DRB Application No.:07DRB-70285 Project # 1003597
Project Name: **ALBAN HILLS**
Agent: ABQ ENGINEERING INC Phone No.:255-7802

CITY OF ALBUQUERQUE
PLANNING DEPARTMENT
October 10, 2007
DRB Comments

RE: Block 15, Tracts 1-D-1-A, 1-E-1-A, Alban Hills/minor plat

PLAT OF
TRACTS 1-D-1-A AND 1-E-1-A, BLOCK 15
ALBAN HILLS UNIT 1

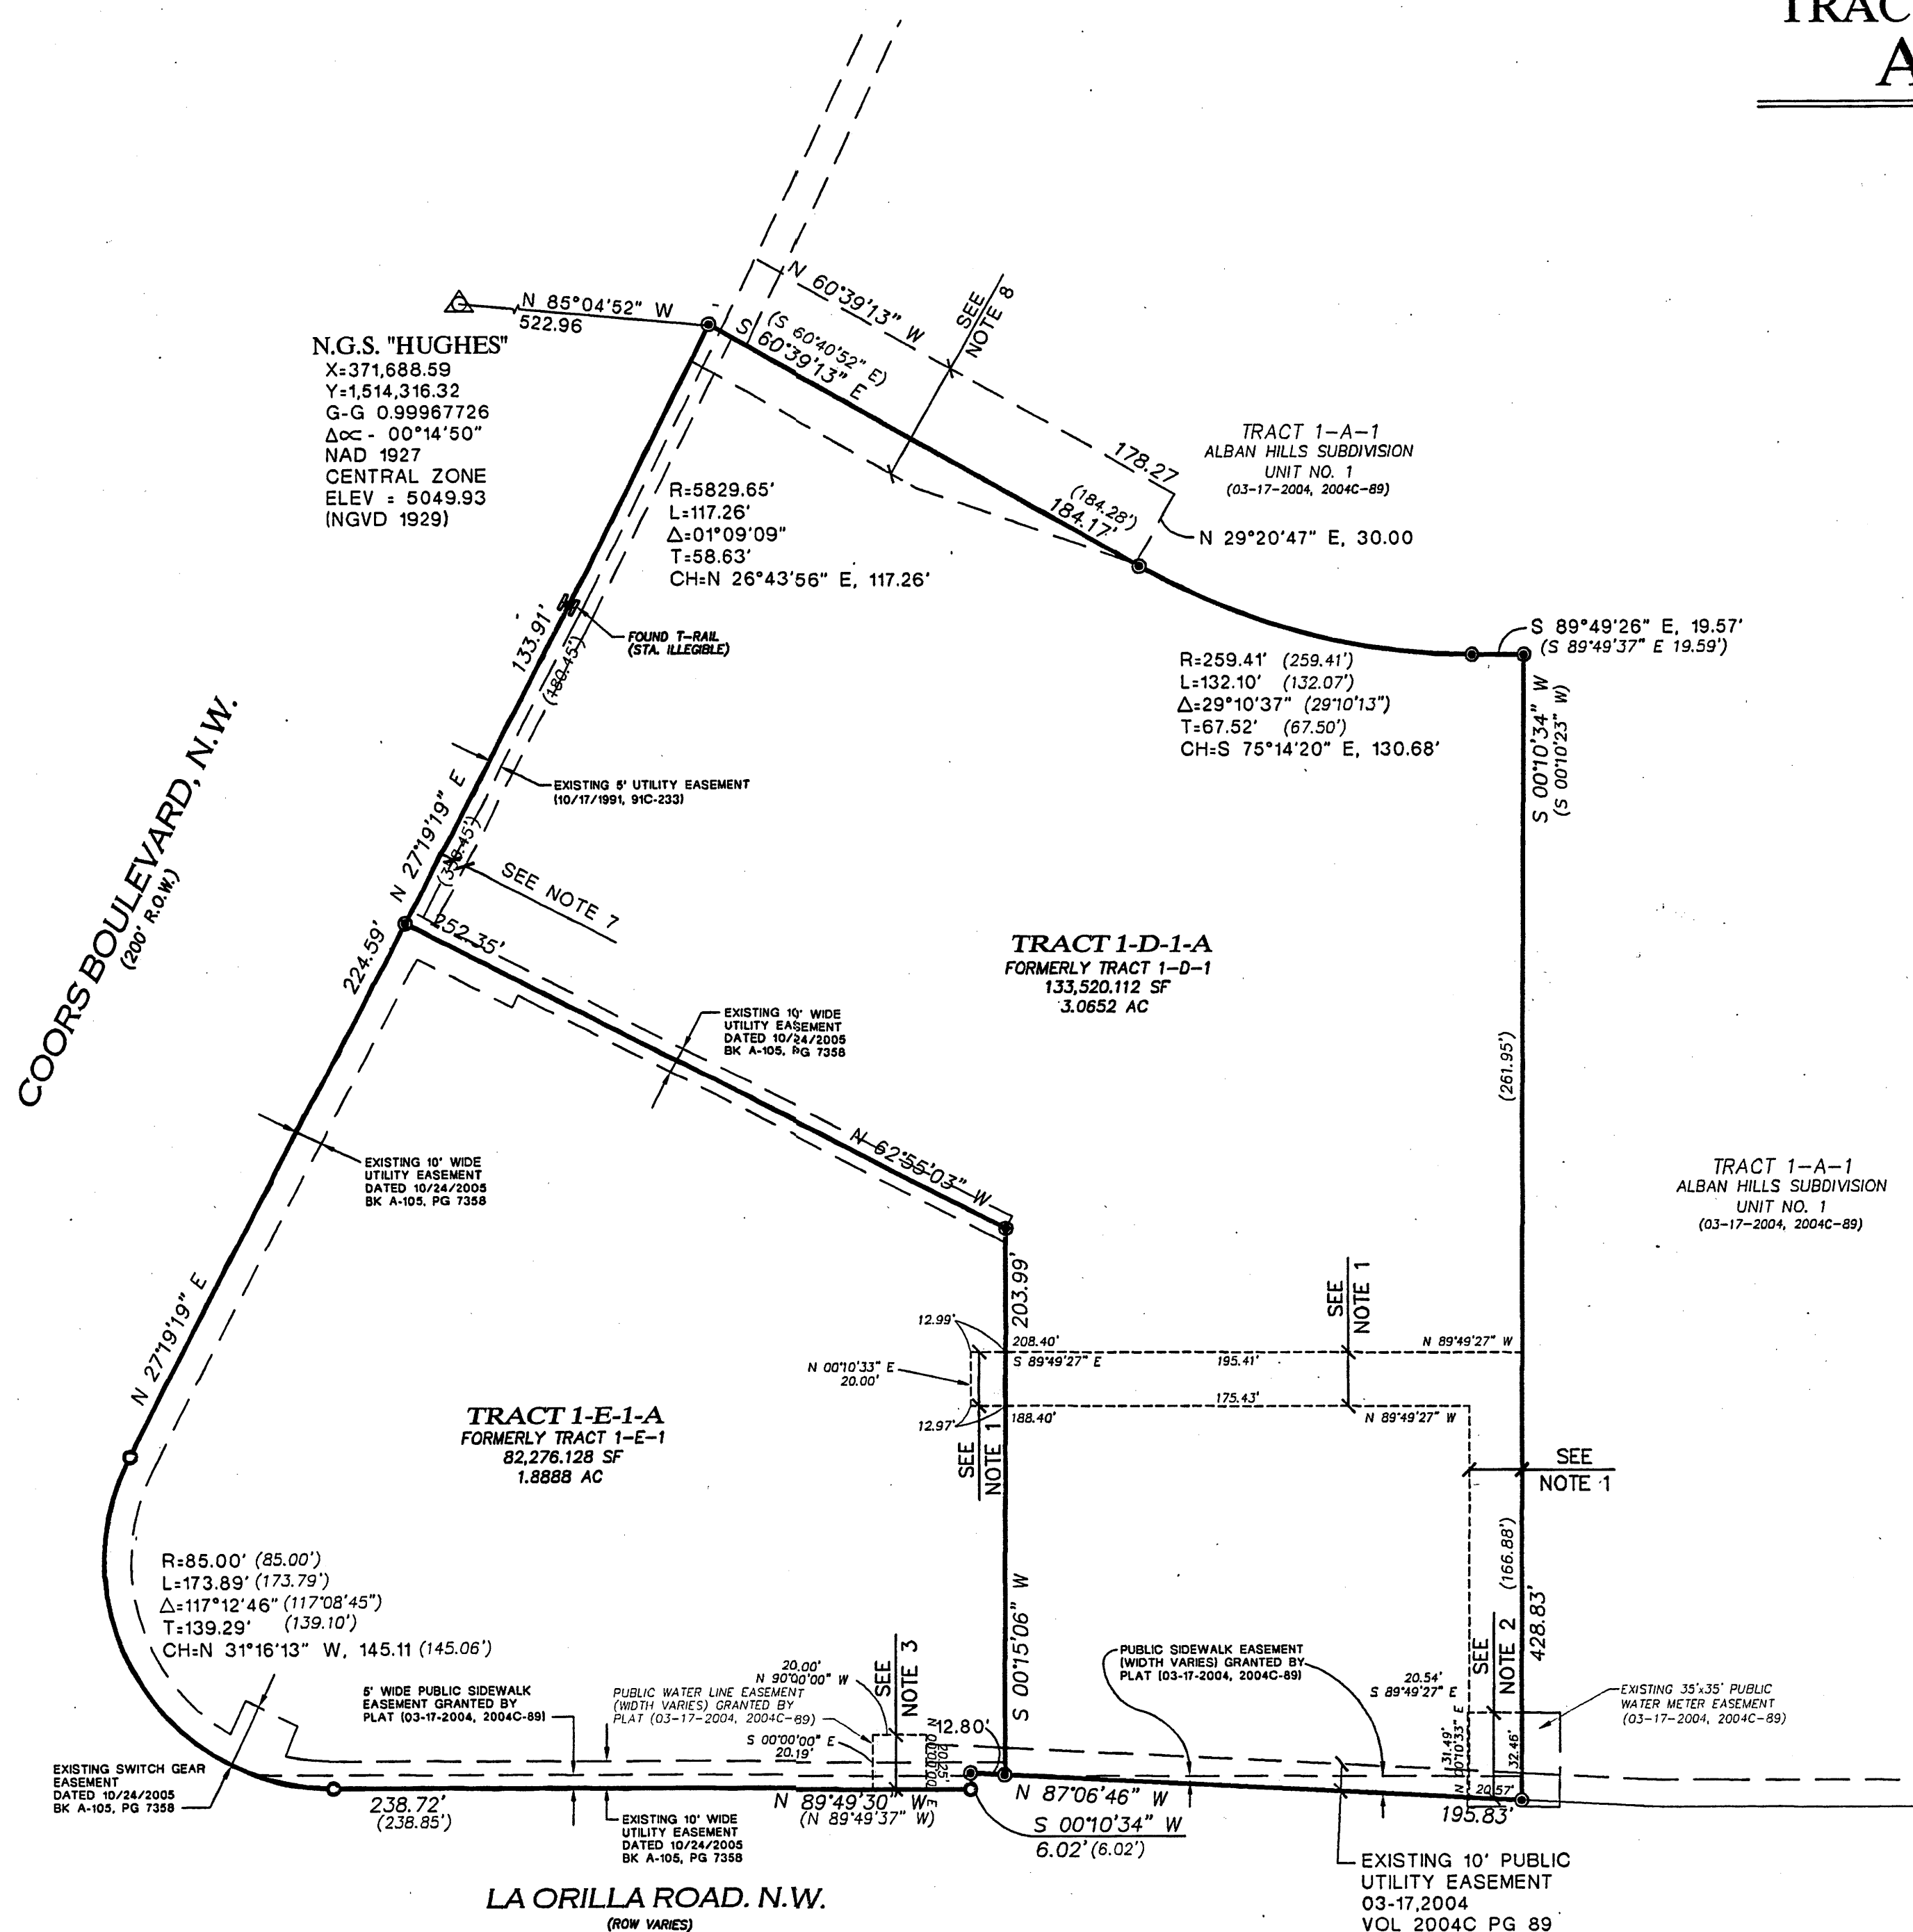
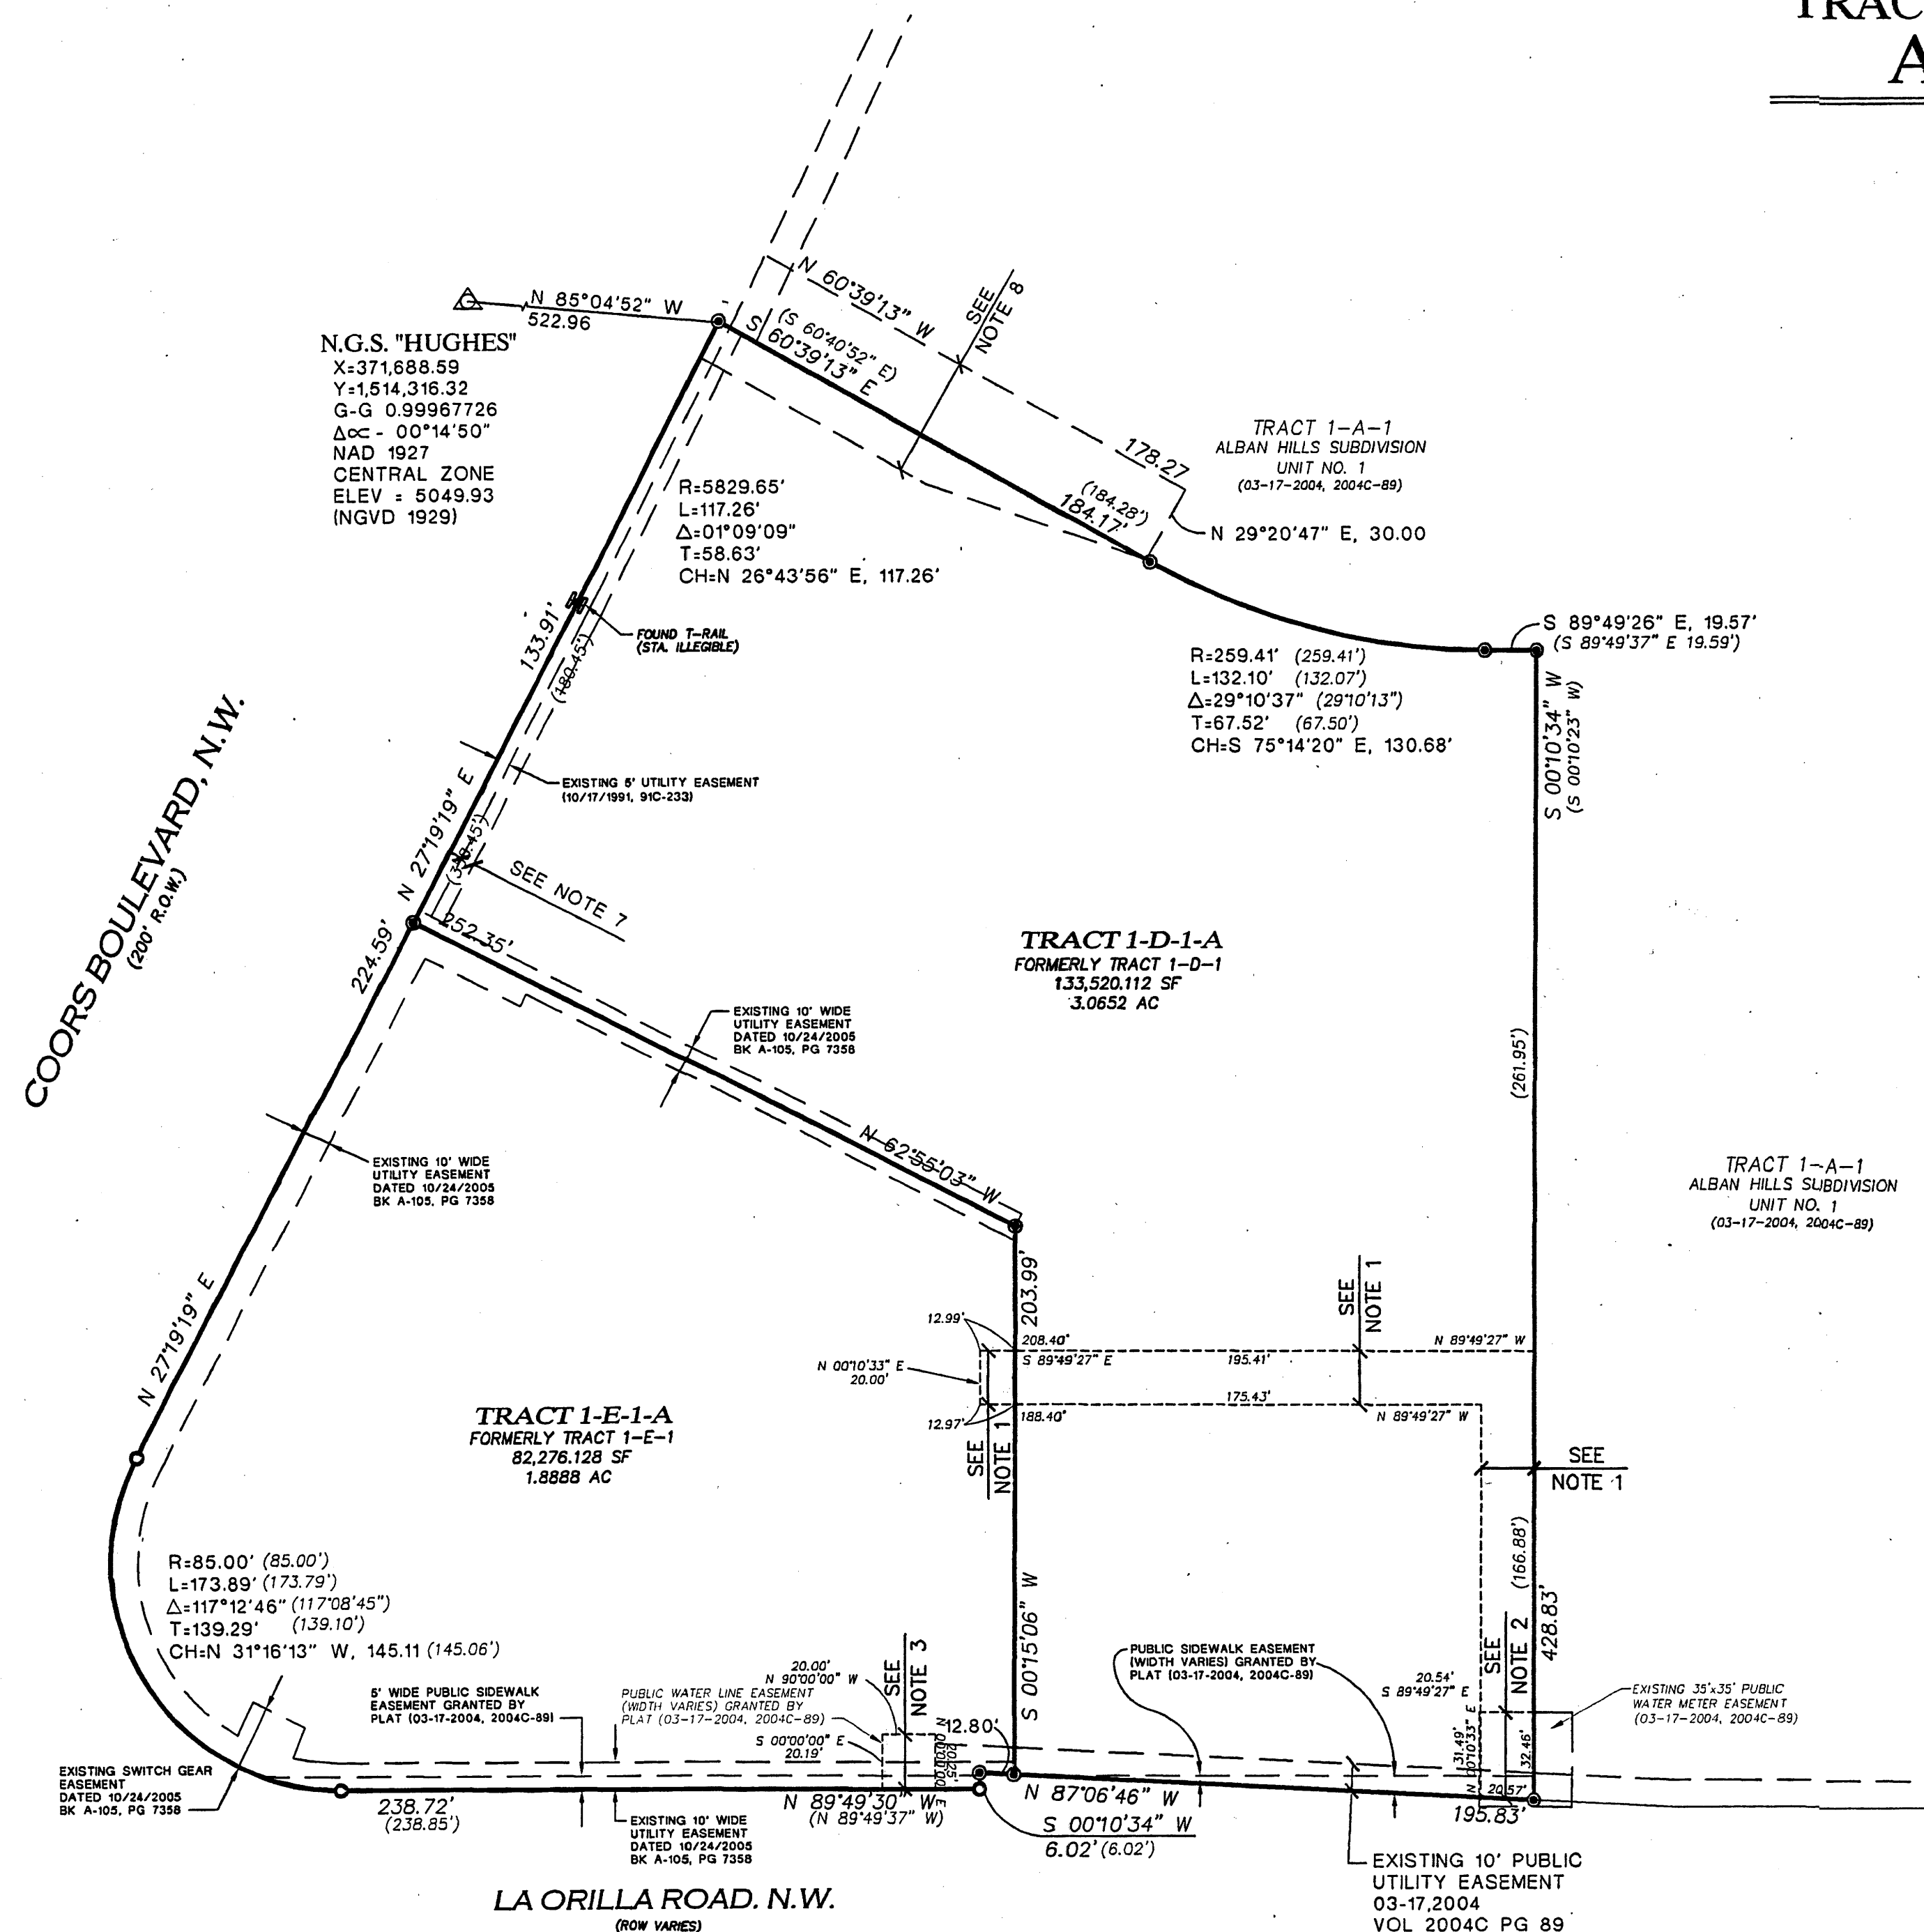
No.	Comment
1	Public improvements need to be contained within right-of-way.

The required ban on solar collectors' prohibition is missing from the plat.

Planning will take delegation to record the plat and for the required solar collector language.
